DEVELOPMENT IMPACT ASSESSMENT REPORT

**SPECTATOR PRECINCT
ROYAL RANDWICK RACECOURSE
77-97 ALISON ROAD, RANDWICK**

September 2010

Title	Author	Dwg No.	Date
<i>Landscape Concept Plan – Spectator Precinct</i>	AECOM	10503376/ L001 Issue C	22/09/2010
<i>Landscape Design Report – Spectator Precinct</i>	AECOM		September 2010

01 PARADE RING SECTION A-A

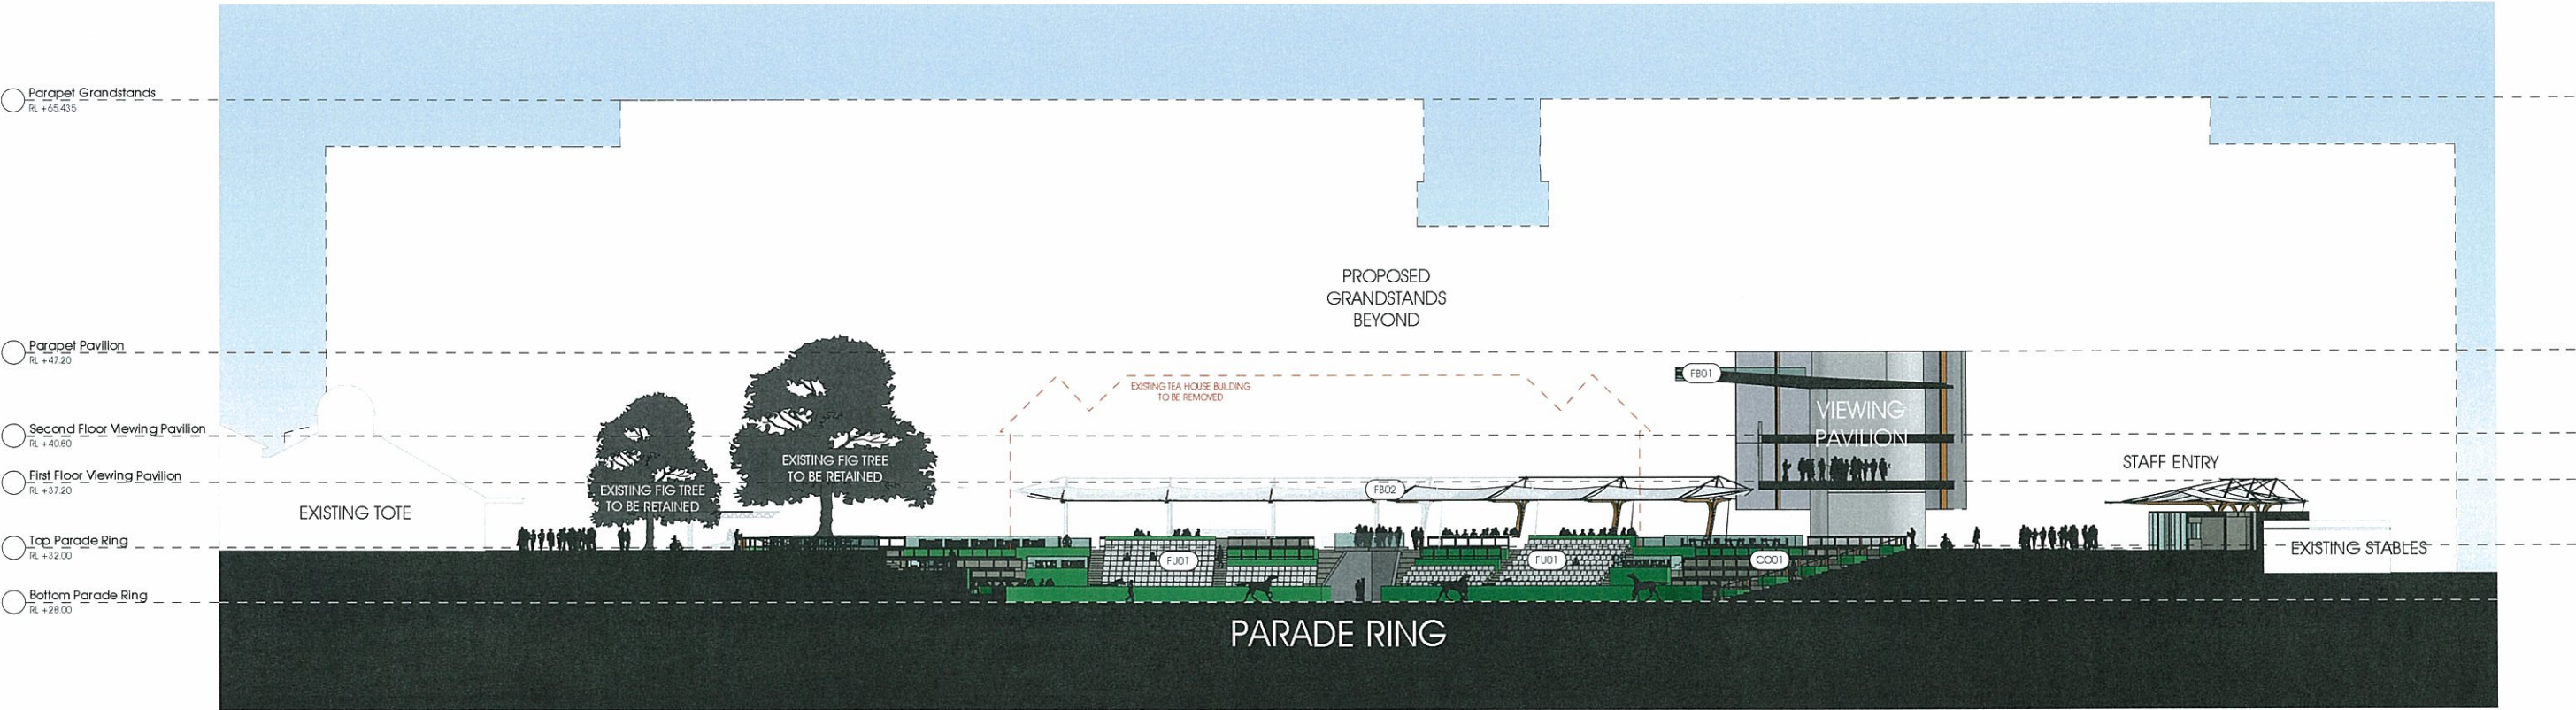
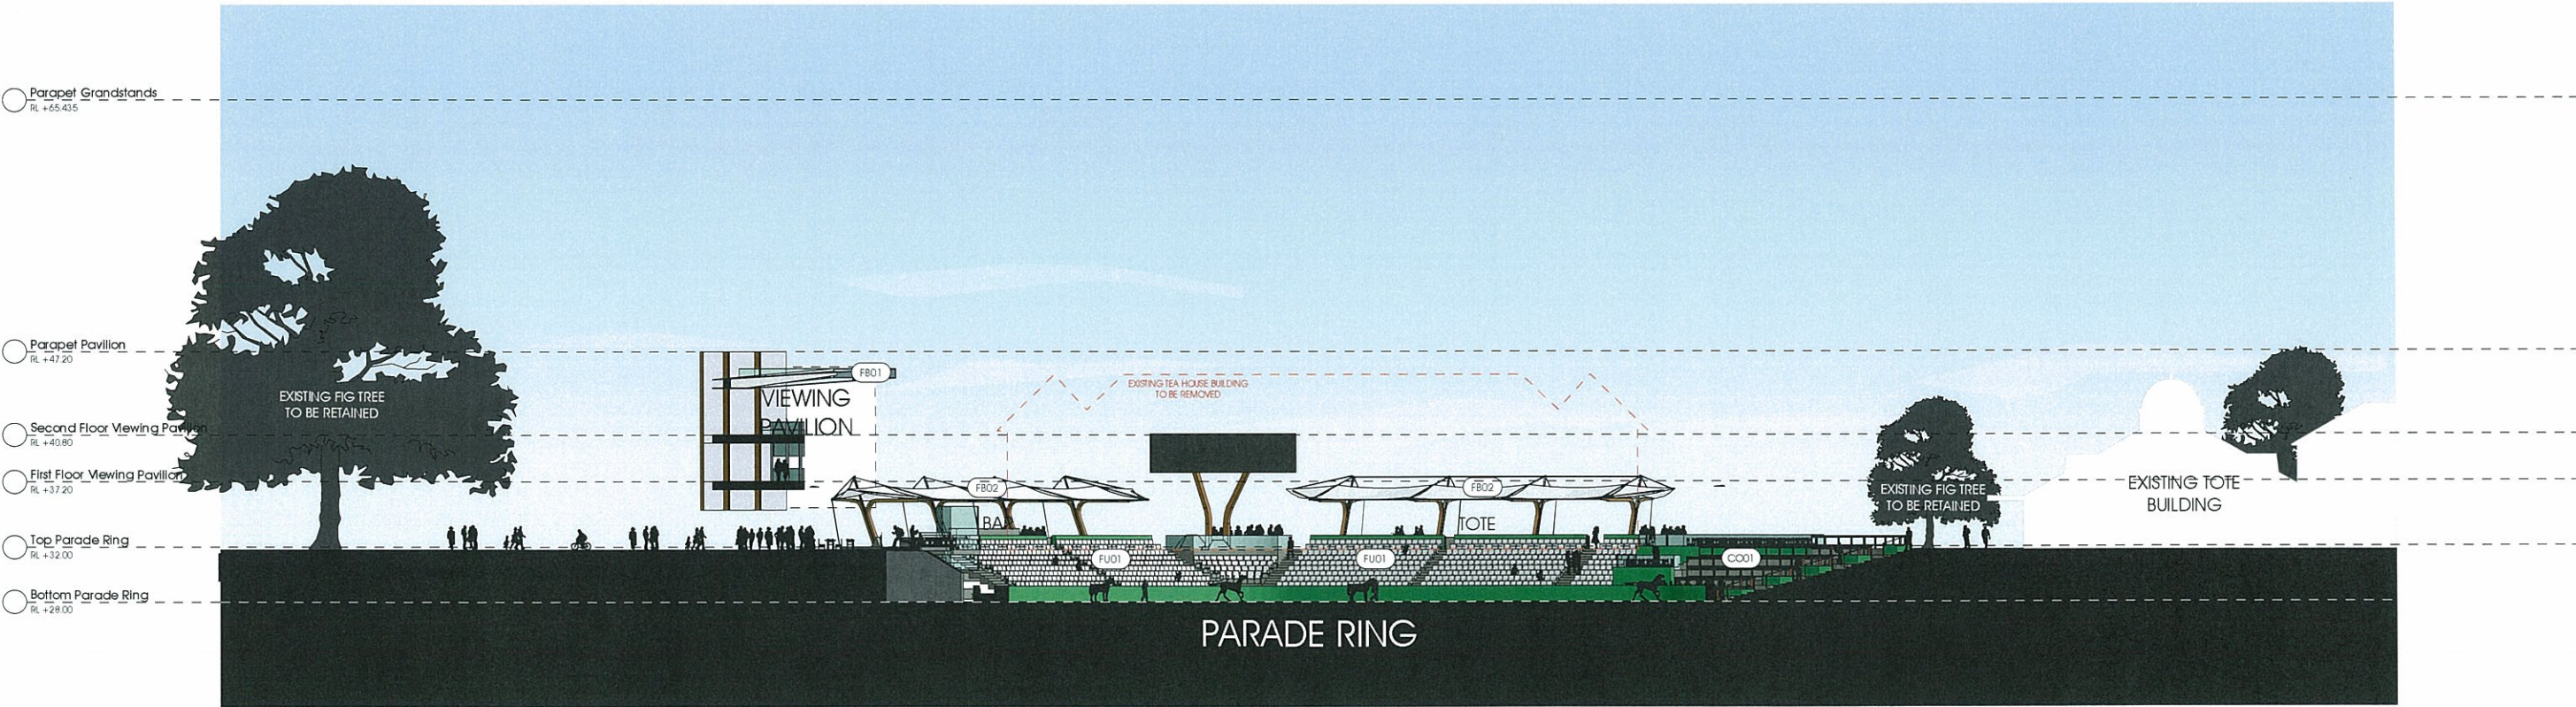
- 9.1.5 Existing paved areas located within the TPZ's of tree No.s T68 & T69 (Port Jackson Figs) and T84 & T85 (Moreton Bay Figs) are proposed to be demolished and replaced with new garden and paved areas. These trees are nominated as 'Exceptional Significance' under the Royal Randwick Racecourse DCP. As these trees have been previously transplanted into raised masonry planter boxes, demolition of the pavements outside the perimeter line of the planter boxes will not result in any adverse impact on these trees. However, proposed new pavements and gardens surrounding these trees currently indicate the reduction in ground levels within the SRZ (within the area of the

planter box). Given the limited remaining root volume following initial transplanting, lowering of the ground level within the planter box will result in a significant adverse impact on these trees. In order to avoid any adverse impact on T68, T69, T84 & T85, the existing ground levels within the area of the raised planter boxes must be kept at existing levels. The existing area occupied by the planters should be maintained as a landscaped or garden area without any new pavement. It is understood that this issue will be resolved during the detailed design stage by adjusting the levels and areas surrounding the trees accordingly to mitigate any adverse impact on them.

- 11.1.7 Proposed new pavements and gardens surrounding tree No.s T68, T69, T84 & T85 currently indicate a reduction in ground levels within the area of the existing raised planter boxes, which would result in a significant adverse impact on these trees. However, it is understood that this issue will be resolved during the detailed design stage by adjusting the surrounding levels as required to ensure that the existing levels within the planter box areas are maintained.

5. In order to avoid any adverse impact on trees T68, T69, T84 & T85, the existing ground levels within the raised planter box areas surrounding each tree should be retained as existing. The existing area occupied by the planters should be maintained as a landscaped or garden area without any new pavement.

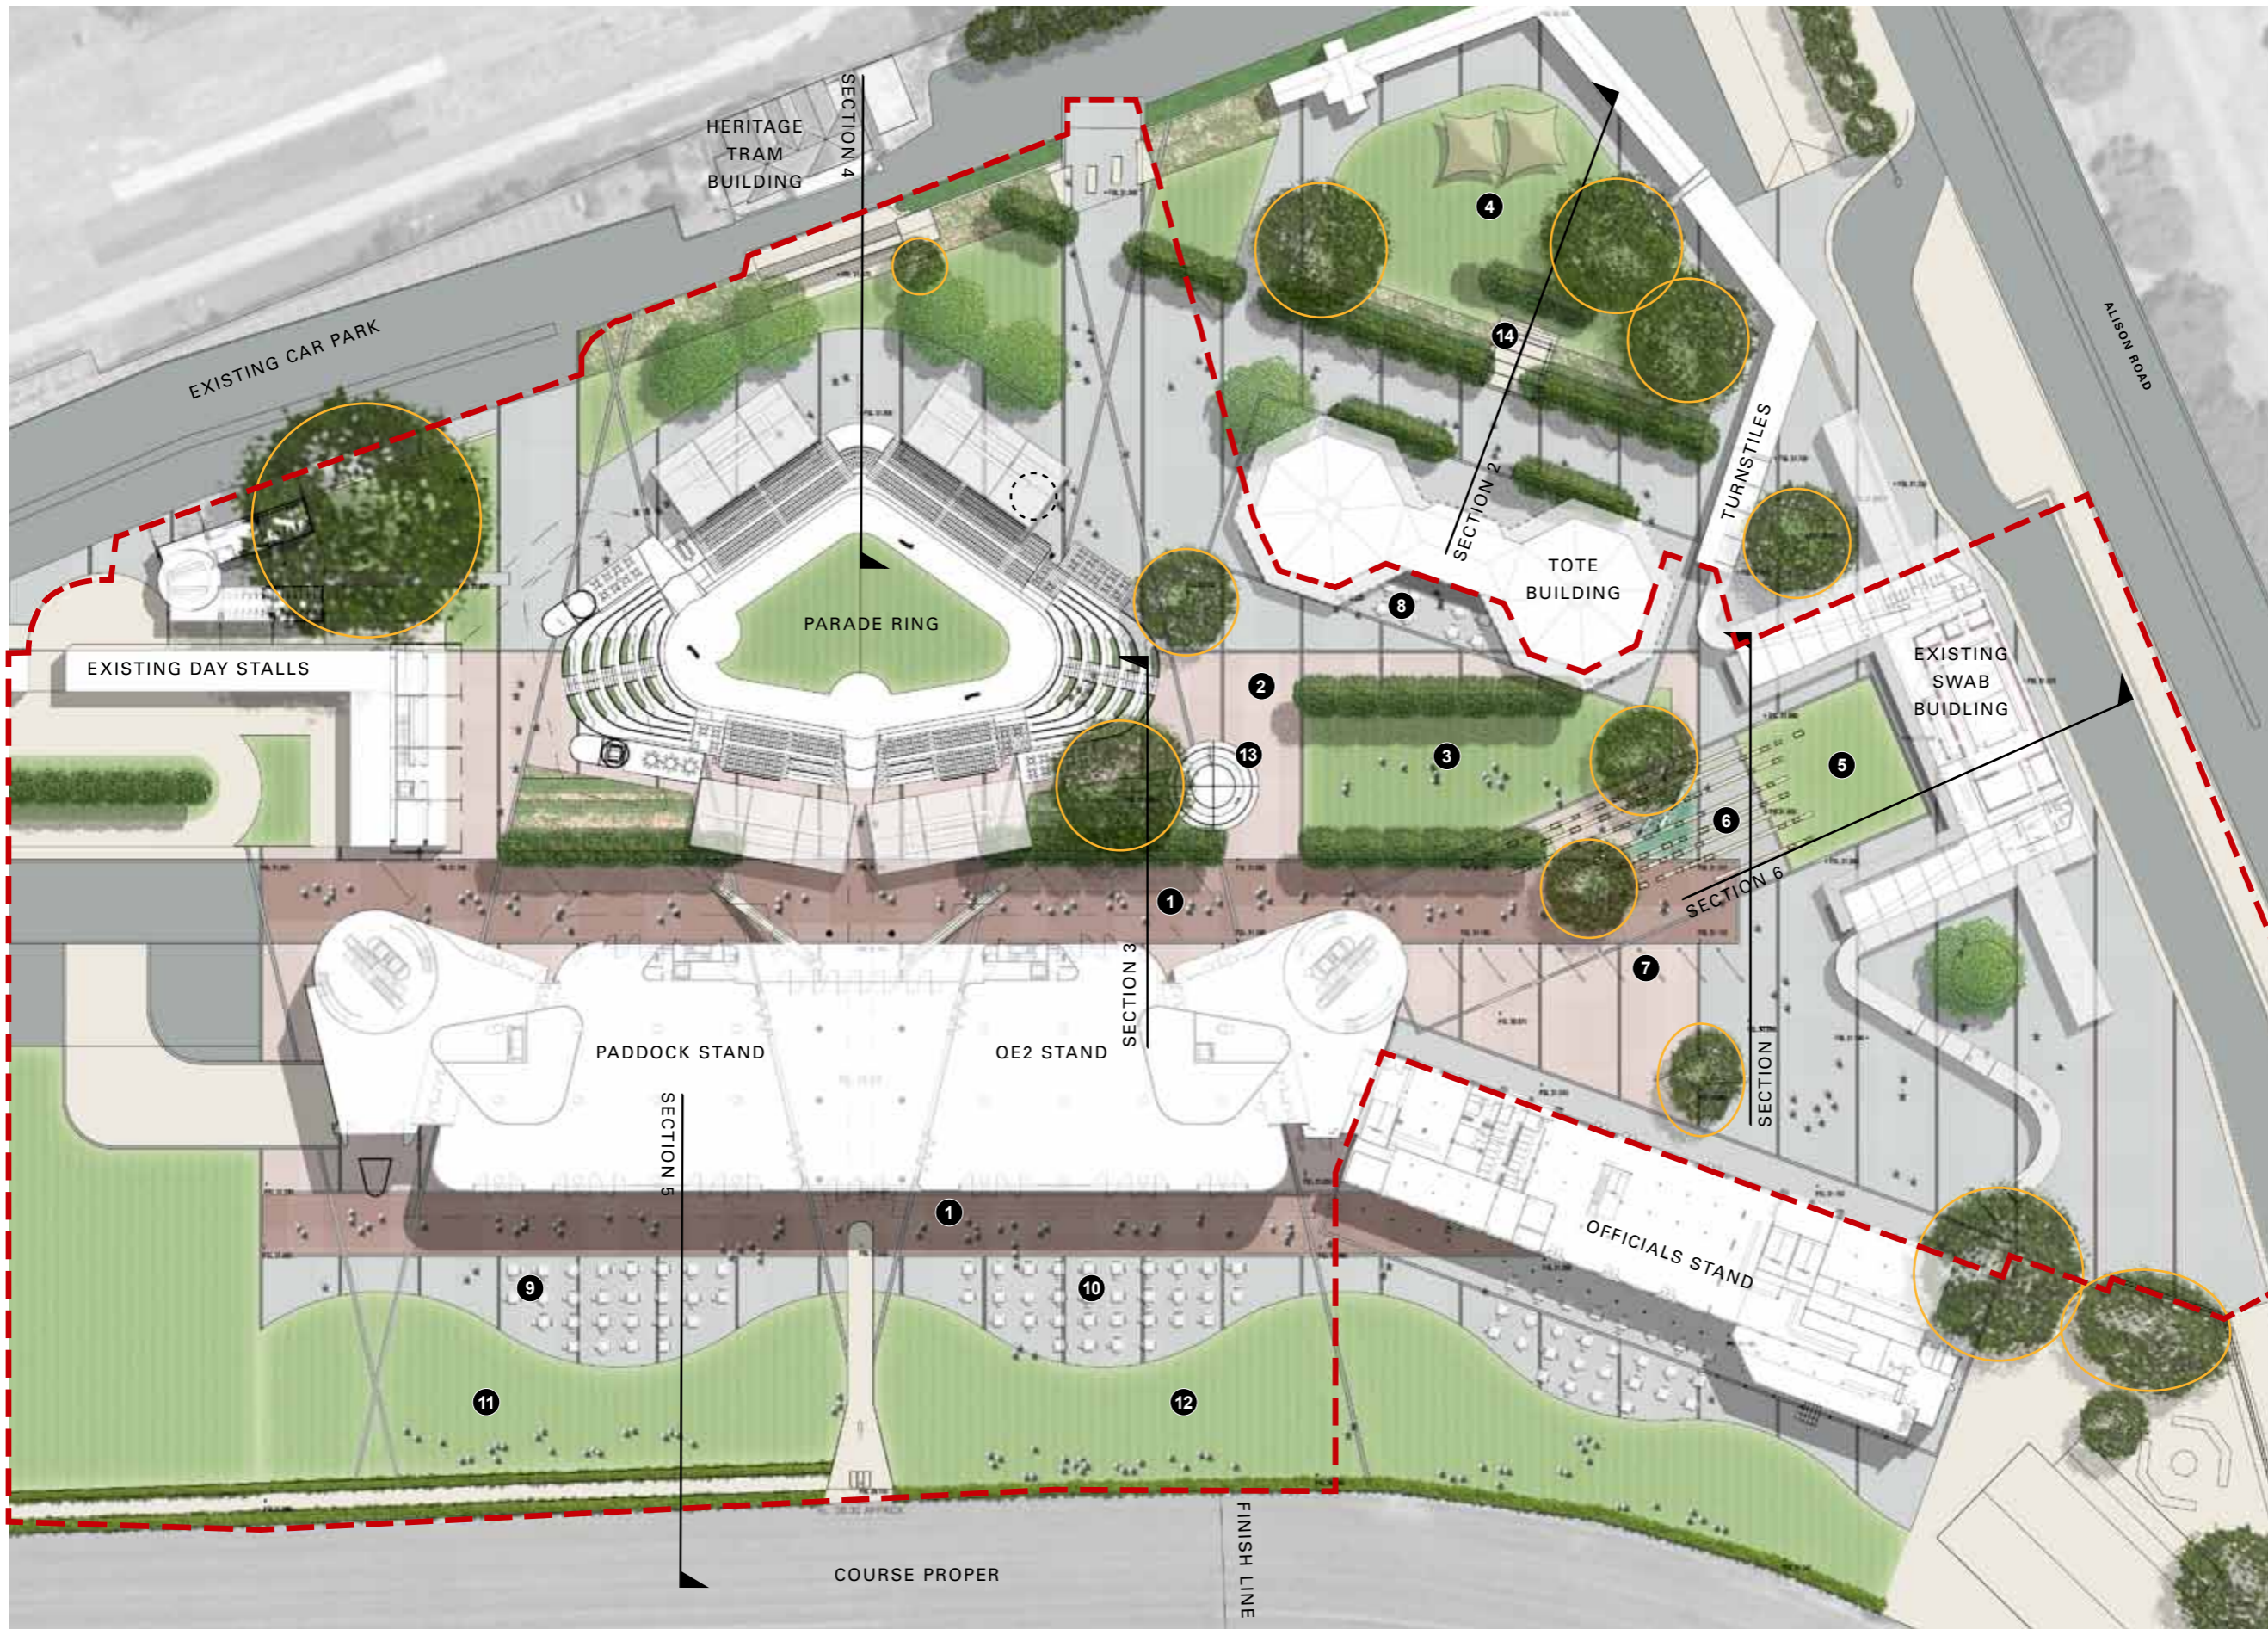
- 9.1.4 Demolition of existing paved areas and pathways are located within the TPZ's of tree No.s T58 (Small-leaf Fig), T61, T62, T64, T77 & T78 (Port Jackson Figs) (nominated as 'Exceptional Significance' under the Royal Randwick Racecourse DCP) and T70 (Brushbox). The proposed demolition work should not result in any adverse impact on these trees provided that the work is carried out in accordance with Section 14.18. Proposed new pavements within the TPZ's of these trees will necessitate some excavation and compaction within their root zones, but the proposed works are largely within the footprint of existing pavements. As such, the new pavement works should not result in any adverse impact on these trees provided that all excavations are undertaken in accordance with Section 14.19. In the case of T58, it is recommended that the proposed pavement be relocated outside the Structural Root Zone, no closer than the footprint of the existing paved area, to avoid severance and damage to woody roots.

- 9.1.6 Proposed new pathways are located within the TPZ/SRZ of T91 (Moreton Bay Fig). This tree is nominated as 'Exceptional Significance' under the Royal Randwick Racecourse DCP. Excavation and compaction associated with the pathway on the western side of the tree may necessitate the severance of woody roots, leading to a significant adverse impact. In order to avoid any adverse impact, consideration should be given to adjusting the alignment and/or width of the pathway/pavement to avoid any encroachment into root zone. Alternatively consideration should be given to placement of the pavement and any kerb or edge restraint above grade to avoid excavations within the TPZ (refer Figure 1). Consideration should also be given to a permeable type pavement surface to maximise water infiltration to the underlying root zone. Drainage works, including pits and pipelines, should be placed outside the recommended Minimum Setback Distance (refer Appendix 5) where possible.

- 11.1.8 Proposed new pathways are located within the TPZ/SRZ of T91. Excavation and compaction associated with the pathway may result in a significant adverse impact on this tree. However, it is understood that this issue will be resolved during the detailed design stage by adjusting the surrounding levels as required to ensure that the existing ground levels within the TPZ of this tree are maintained.

11.1.9 A proposed new amenities block located within the TPZ of T91 may result in an adverse impact on this tree. In order to avoid adverse impact, consideration should be given to relocating the amenities block further south, outside the TPZ (15 metres radius).

2. The proposed pavement on the south-western side of T58 should be relocated outside the Structural Root Zone, no closer than the footprint of the existing paved area, to avoid severance and damage to woody roots

6. In order to avoid any adverse impact on T91, consideration should be given to altering the alignment or width of the proposed pathway on the western side of this tree or alternatively installing a permeable pavement above existing ground levels to minimise the incursion to the root zone. Consideration should also be given to relocating the proposed amenities block outside the TPZ

7. In order to avoid any adverse impact on T91, consideration should be given to relocating the proposed amenities block outside the TPZ of this tree (15 metres radius).
